Your Ref: 20/04211/PLF  
Our Ref: X000370

29th January 2021

**Sun Inn Church Lane Skirlaugh - Erection of four dwellings and associated car parking following demolition of existing public house (revised scheme of 18/04064/PLF)**

THE SUN INN.

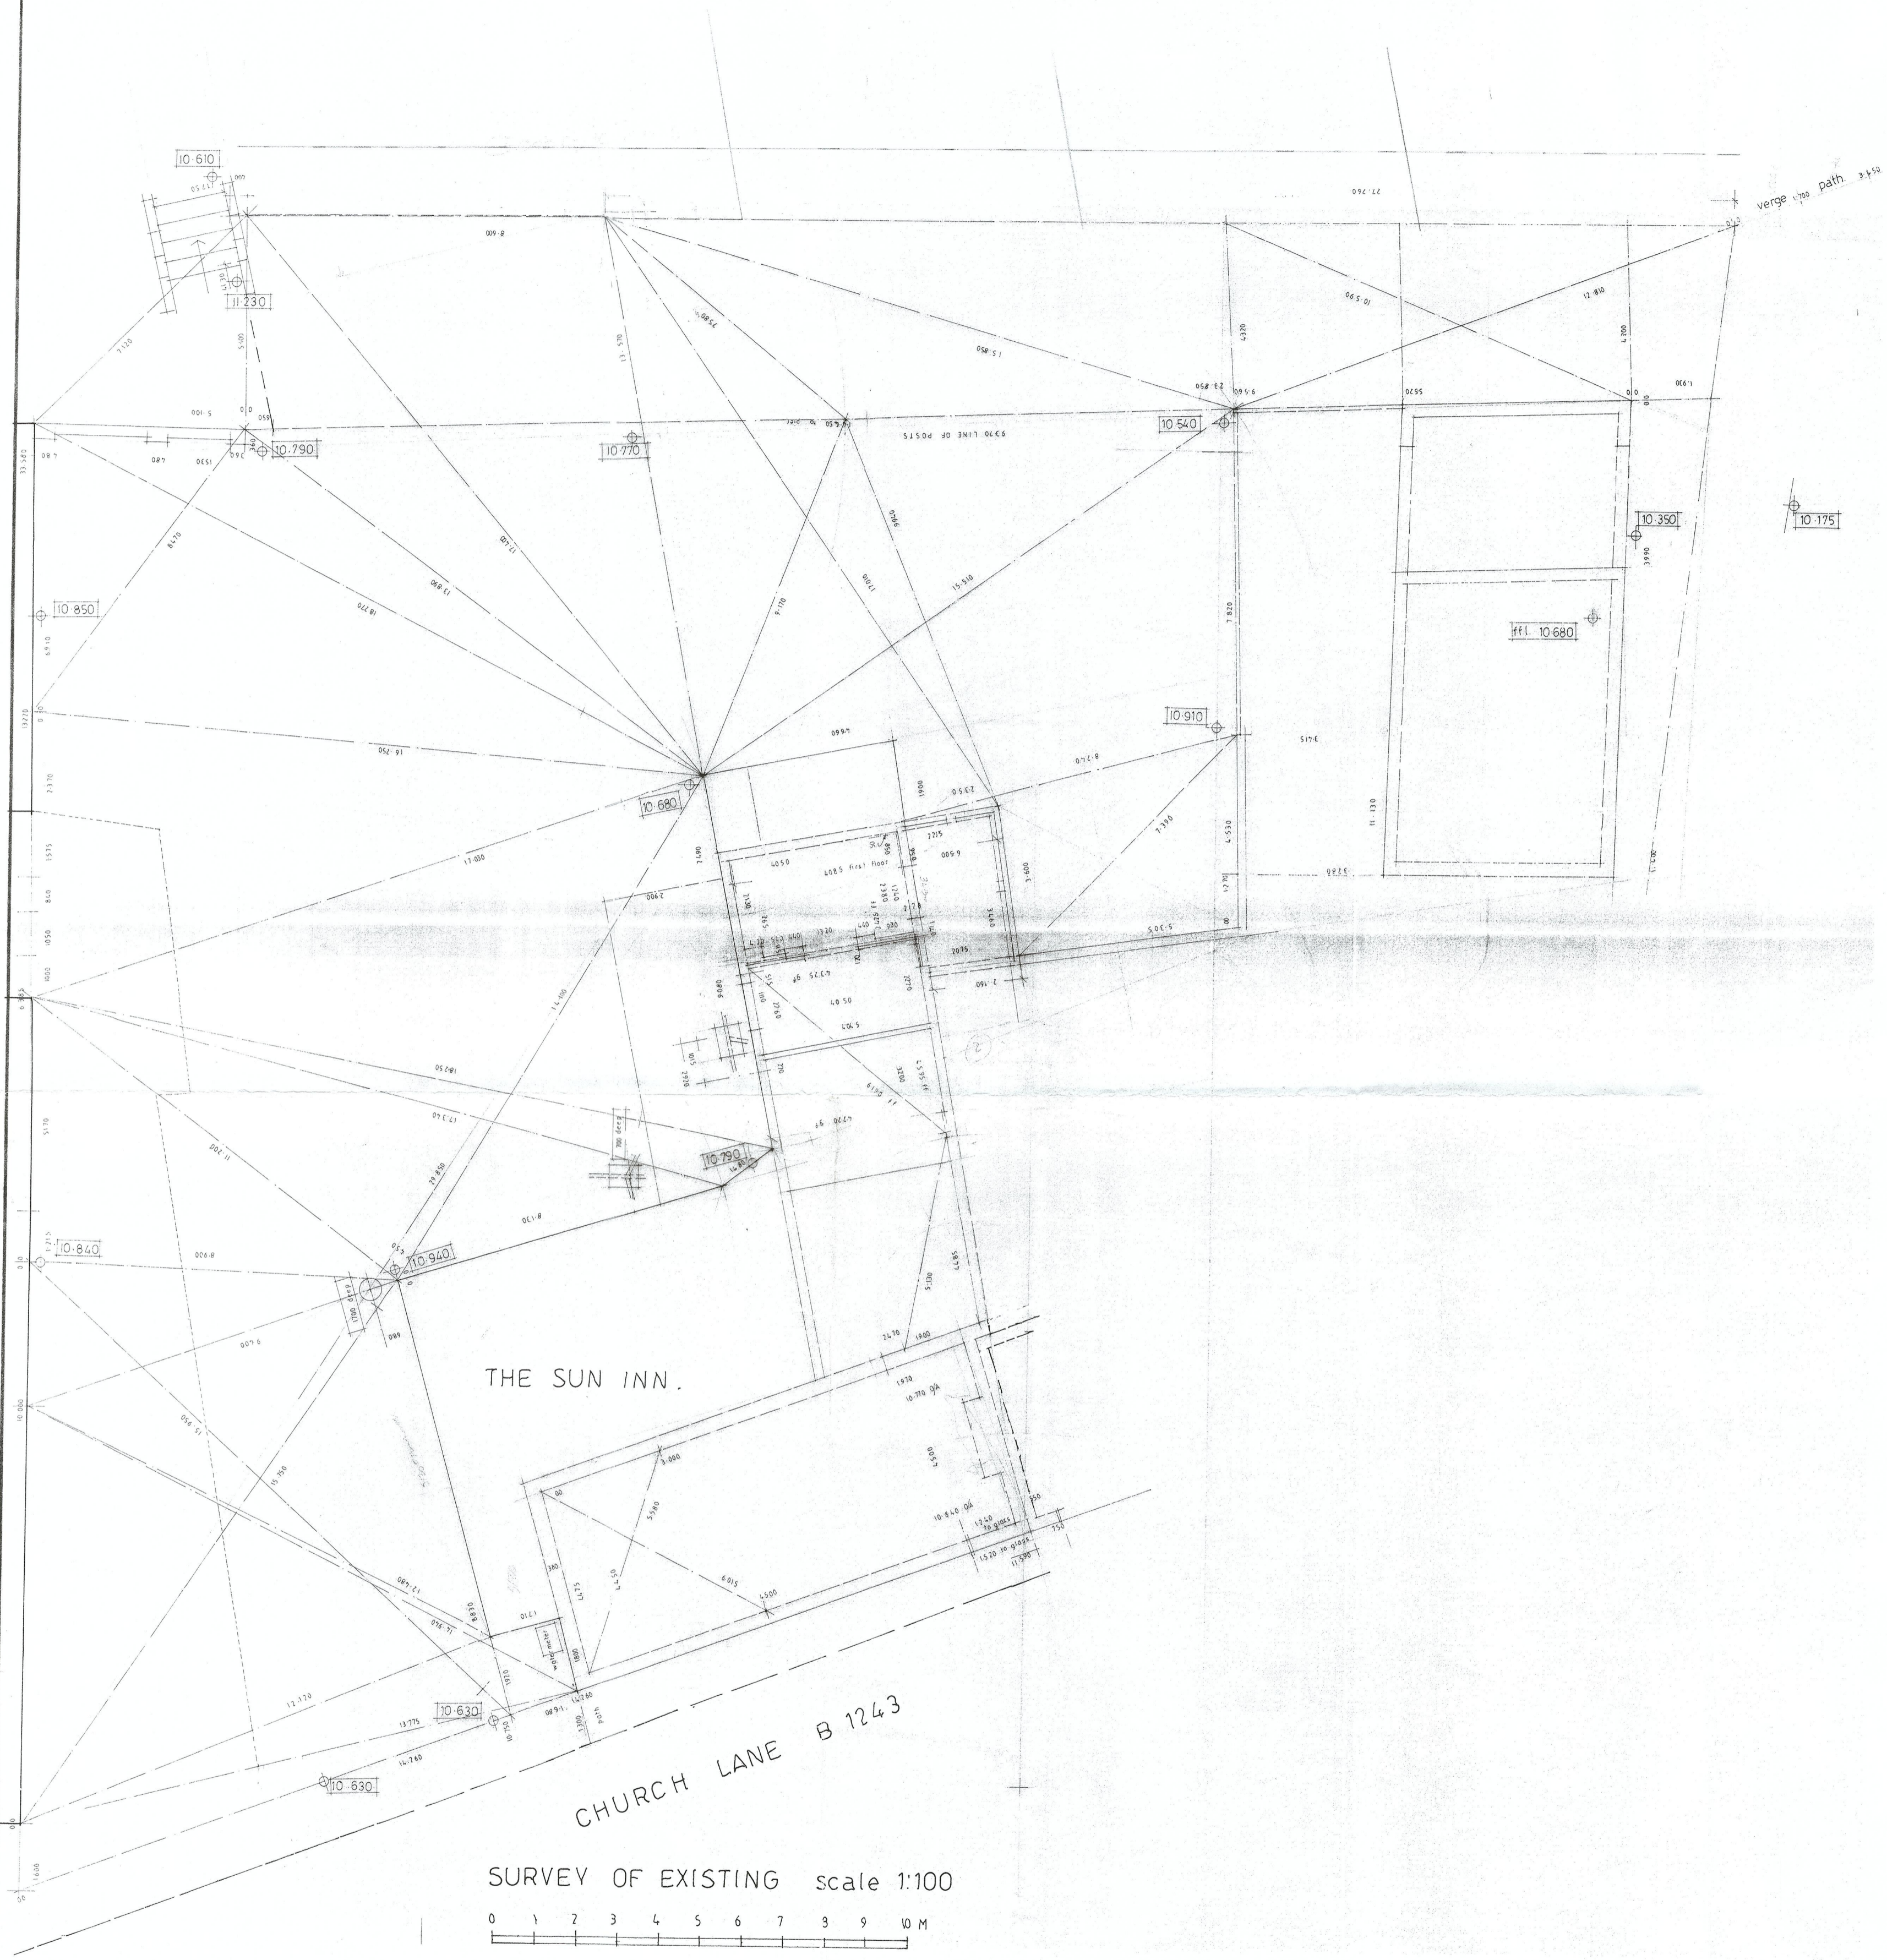
The drainage details submitted on drawing L591.2 (revision B) are NOT acceptable to Yorkshire Water. The following points should be addressed. For further information, the developer should contact our Developer Services Team (telephone 0345 120 84 82, technical.sewerage@yorkshirewater.co.uk):

- 1) it is understood that surface water is intended to discharge to public surface water sewer. However there is no evidence of infiltration being discounted, evidence of positive connectivity or any flow management proposals.
- 2) evidence should be submitted to show that other (than discharge to public sewer) means of surface water disposal have been considered and why they have been discounted
- 3) evidence of existing impermeable areas positively draining to the public sewer is required to prove rate of discharge. If no evidence of positive connectivity is presented, the surface water discharge rate should be limited to no more than 3.5 (three point five) litres/second .
- 4) the submitted drawing should show surface water storage and flow control rate

On the Statutory Sewer Map, there is a 150 mm diameter public foul surface water sewer recorded to cross the site. It is essential that the presence of this infrastructure is taken into account in the design of the scheme.
